## Local Policing Branch

Your Ref: BN/51/16/RES

Our Ref: NW/ARU/16/23C

**RE: Land at former Pollards Nursery Lake Lane, Barnham**

POLLARDS NURSERY, BARNHAM - SITE LAYOUT

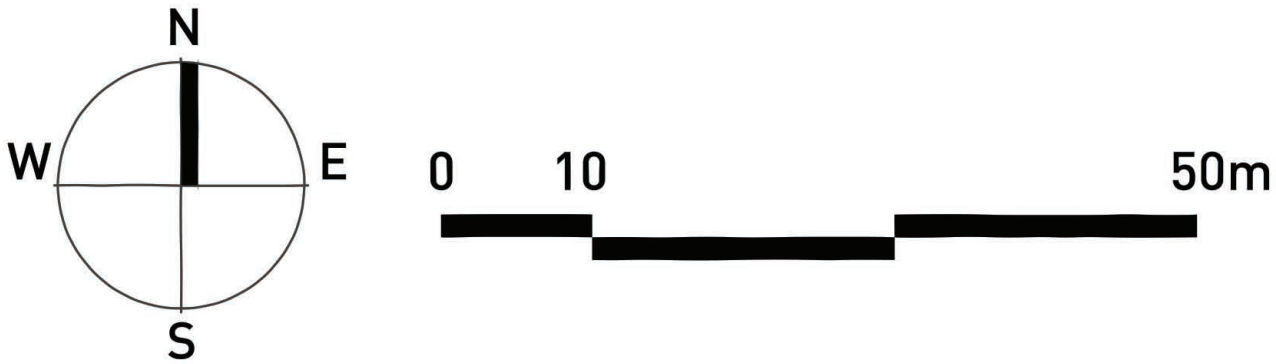
I note that a footpath leading to back garden gates at the back of plots 31 to 40 at the east side of the development and 40 to 49 on the south side have shared gated access and I would recommend that the gates are lockable.

I would also recommend street lighting across the development meets BS5489:2013, and the unallocated parking bays immediately to the west of the allotment area are also illuminated, as a view into the area is limited from nearby housing.

I am pleased to see the LEAP is now overlooked by nearby housing and fenced.
